## **BCA ASSESSMENT REPORT**

**OAKDALE SOUTH ESTATE  
SITE 3B - TOYOTA  
MILNER AVENUE, HORSLEY PARK**

**PREPARED FOR:  
GOODMAN PROPERTY SERVICES (AUST) PTY LTD**

Date: 11.08.2016

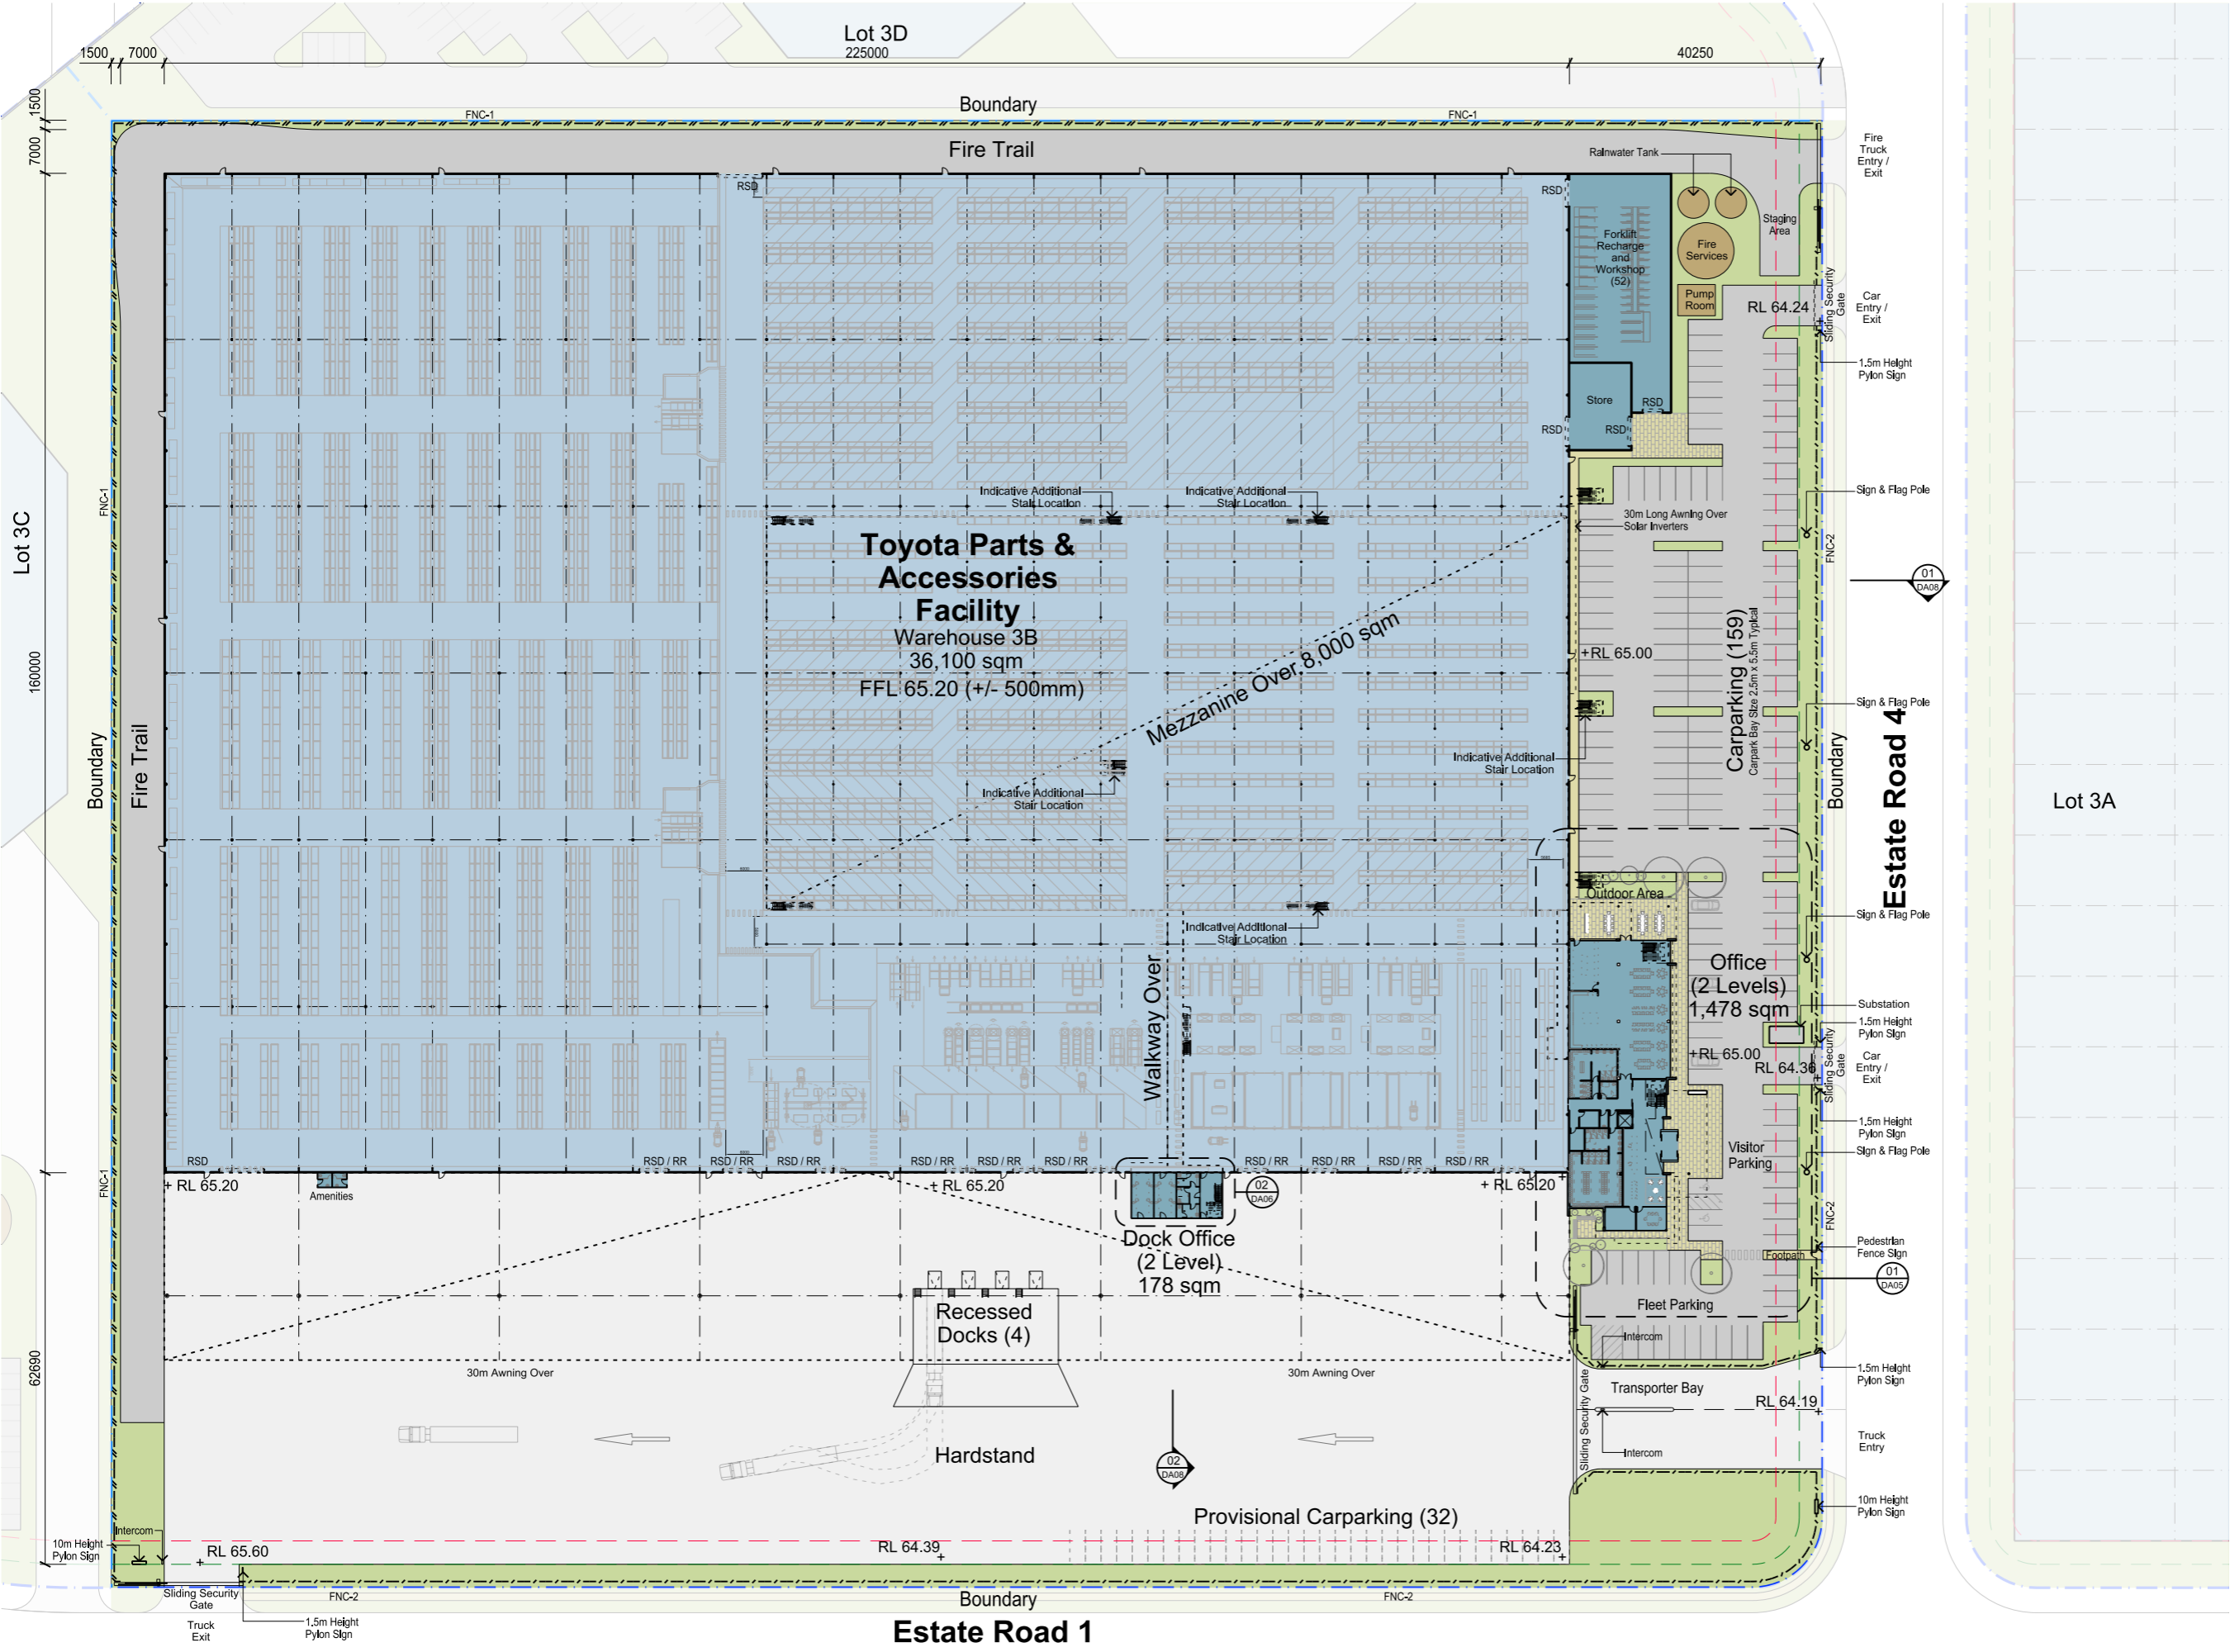
BCA Clause/s		Description
1.	C2.4	The following compliance issues have been identified with respect to the proposed perimeter vehicular access serving Site 1C: + The vehicle access northern side and NE corner of the building is greater than 18m from the building via Estate Rd No.4 and the hardstand access driveway (up to 53m).

- + The vehicle access on the Northern side and the NE corner of the building is greater than 18m from the building (up to 53m) as circled below.

*Comments: It will be necessary for an alternative solution to be prepared to address these non-compliance issues below, in order to demonstrate compliance with Performance Requirement CP9. The departures from this clause are as follows:*
